Project Title: ALICE TOWN HOMES Building Permit #: _____ City Drainage #: J18D043
 DRB#: 1009600 EPC#: _____ Work Order#: _____
 Legal Description: LOTS 7-9 BLOCK 13 MCCAFFREY AND LOTS 7-12 WILLIS SUBDIVISION
 City Address: 5600 ALICE NE

**RE: Drainage Certification Resubmittal
5600 Alice
J18-D043**

The purpose of this letter is to accompany the revised grading certification plan. The plan has been revised to address your written comments dated June 11, 2015. The following is a summary of your comments and the corrections we have done to address.

**Re: Alice Townhomes
5600 Alice NE
Request Permanent C.O. – Not Accepted
Engineer's Stamp dated: 9-16-14 (J18D043)
Certification dated: 6-10-15**

DRAWING TITLE
GRADING AND DRAINAGE PLAN

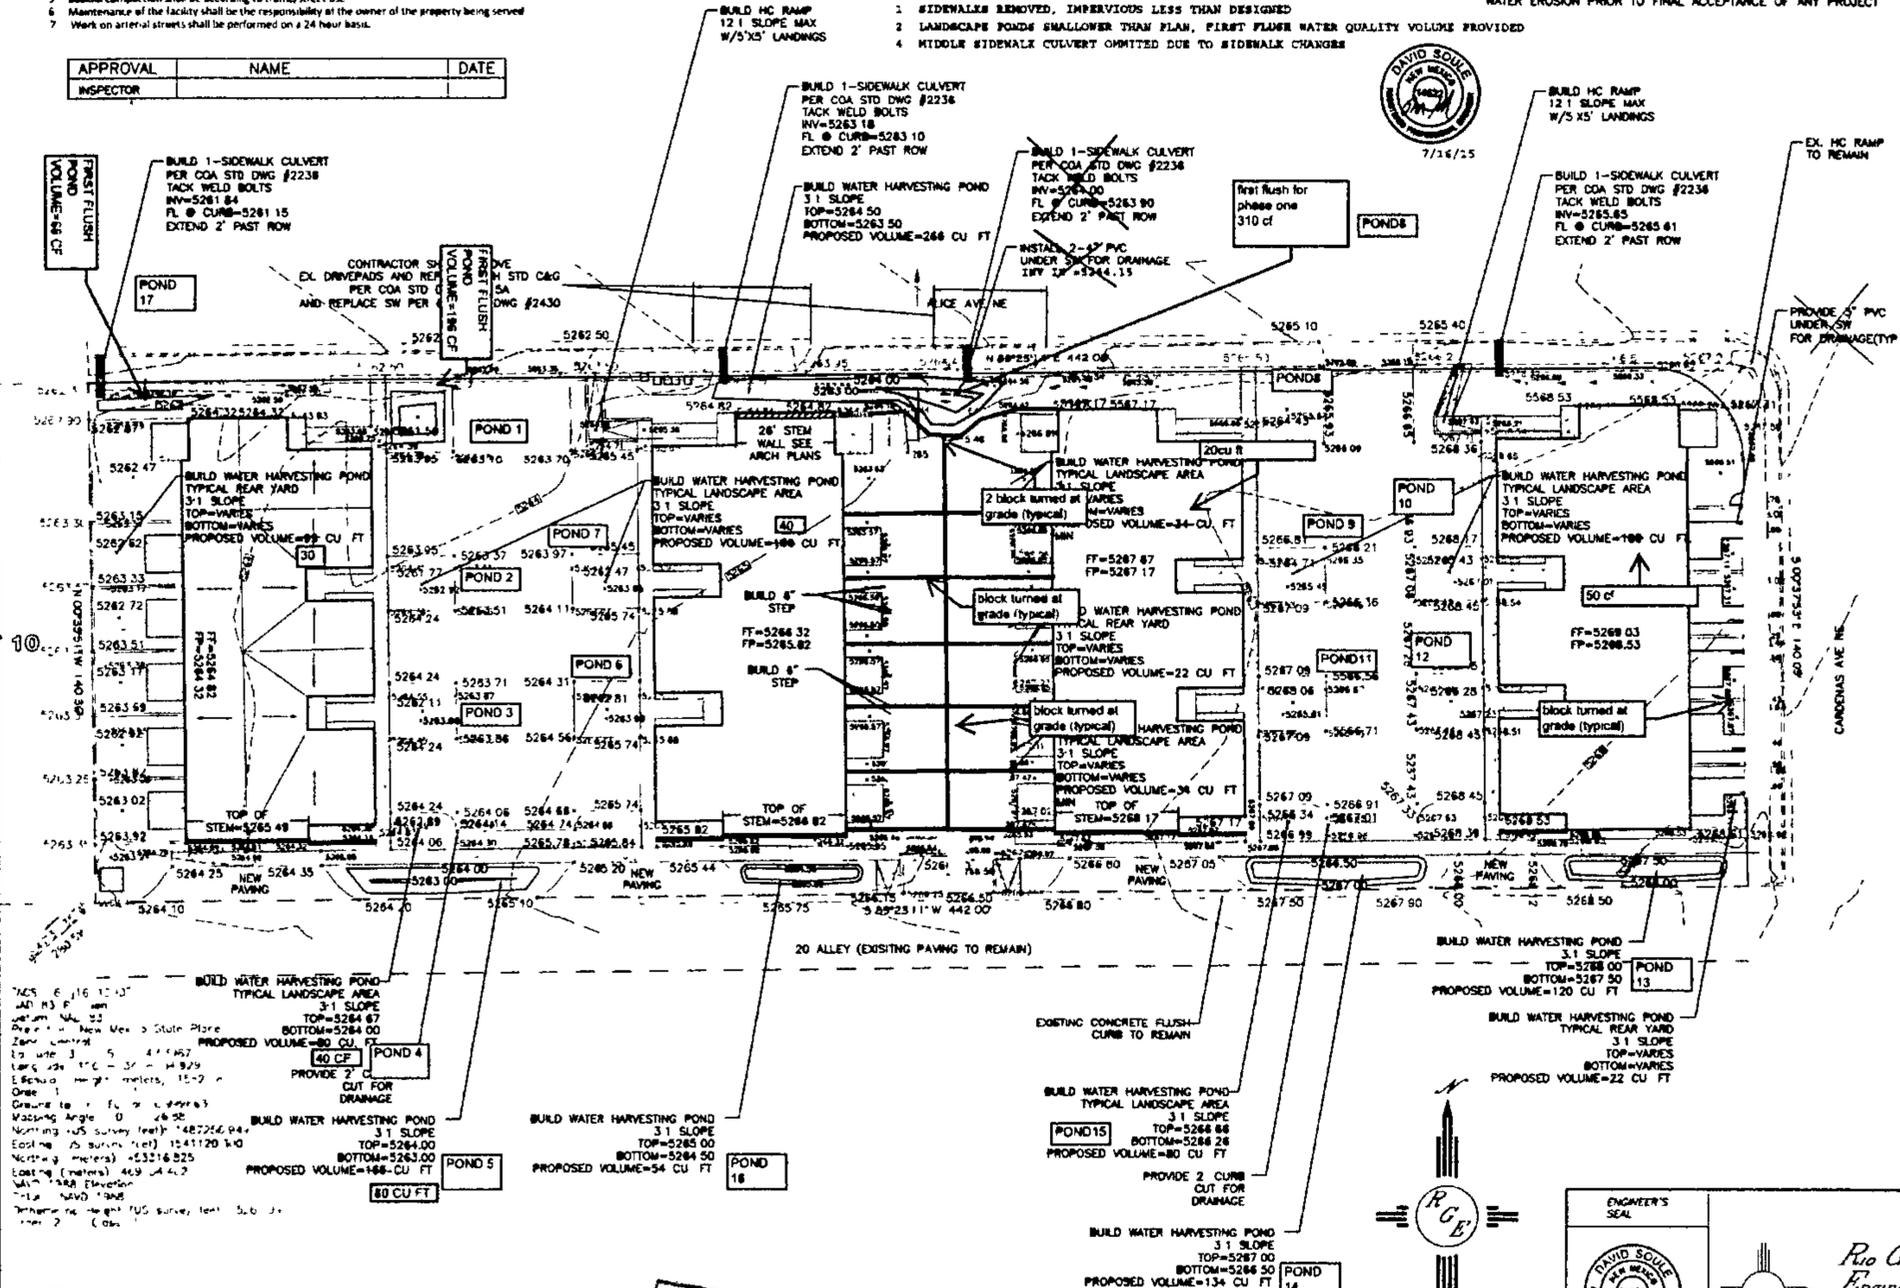
- This plan does not match what was built. A new submittal will be required with a new G&D approval process, after which, the CO will be reevaluated.

1. This plan does not match what was built a new submittal will be required with a new grading and drainage approval process.
We have made the changes clearer on the plan, in addition we have printed in color. We feel the plan accurately reflects the as built conditions as measured by survey and by visual inspection. We feel the omission of a significant amount of sidewalk provides for less discharge than previously approved. In addition modifications were made to provide for the first flush volume, even though the plans were approved prior to the implementation of the rule. We certify the site is shown as constructed and drawn on the original grading plan. We certify the site was graded in substantial compliance with the original design intent. The zoning and site plan approval is outside this certification, we are certifying the grading only. We feel the requirement to resubmit a new plan is not appropriate, the omission of sidewalks interior to the site do not have negative impact on the hydrology and request the attached grading certification be accepted.
